28 October 2019

SF2017/281322; WST17/00197/08

**SSD-9505: Lot 1 DP 1058009 and others; 2816 Mid-Western Highway (HW6), Kings Plains
Environmental Impact Statement (EIS)
McPhillamys Gold Mine with 8 Mtpa extraction limit**

A diagram of an AUL turn treatment on the major leg of a rural road is shown in Figure 8.4. The length of the auxiliary left-turn lane should not be restricted to the minimum if there is little difficulty in making it longer and the demand warrants the treatment (Section 4.8).

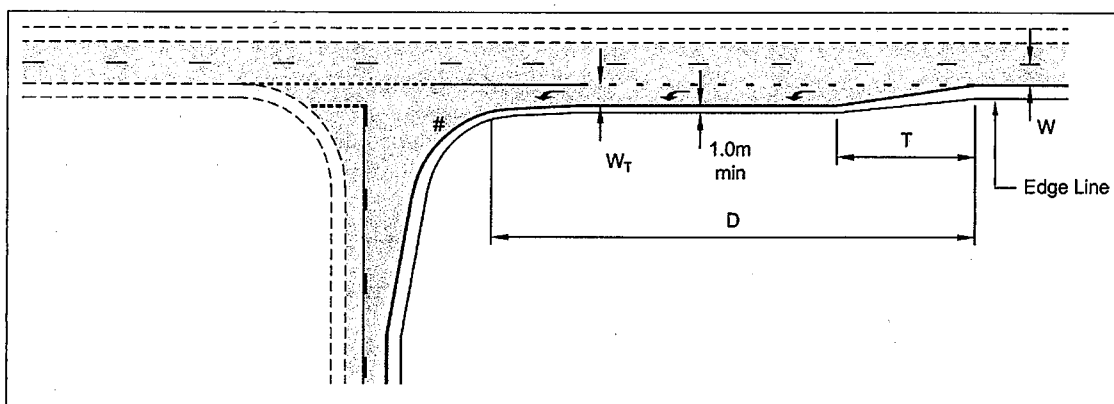
- Prior to commencement of any construction work, an Auxiliary Left turn treatment (AUL) as shown in Figure 8.4 Part 4A of *Austroads Guide to Road Design* (copy enclosed), and relevant Roads and Maritime supplements is to be provided at the proposed intersection with the Mid Western Highway. The intersection works are to be designed and constructed for a 100km/h posted speed zone and be able to accommodate the largest vehicle accessing the intersection.
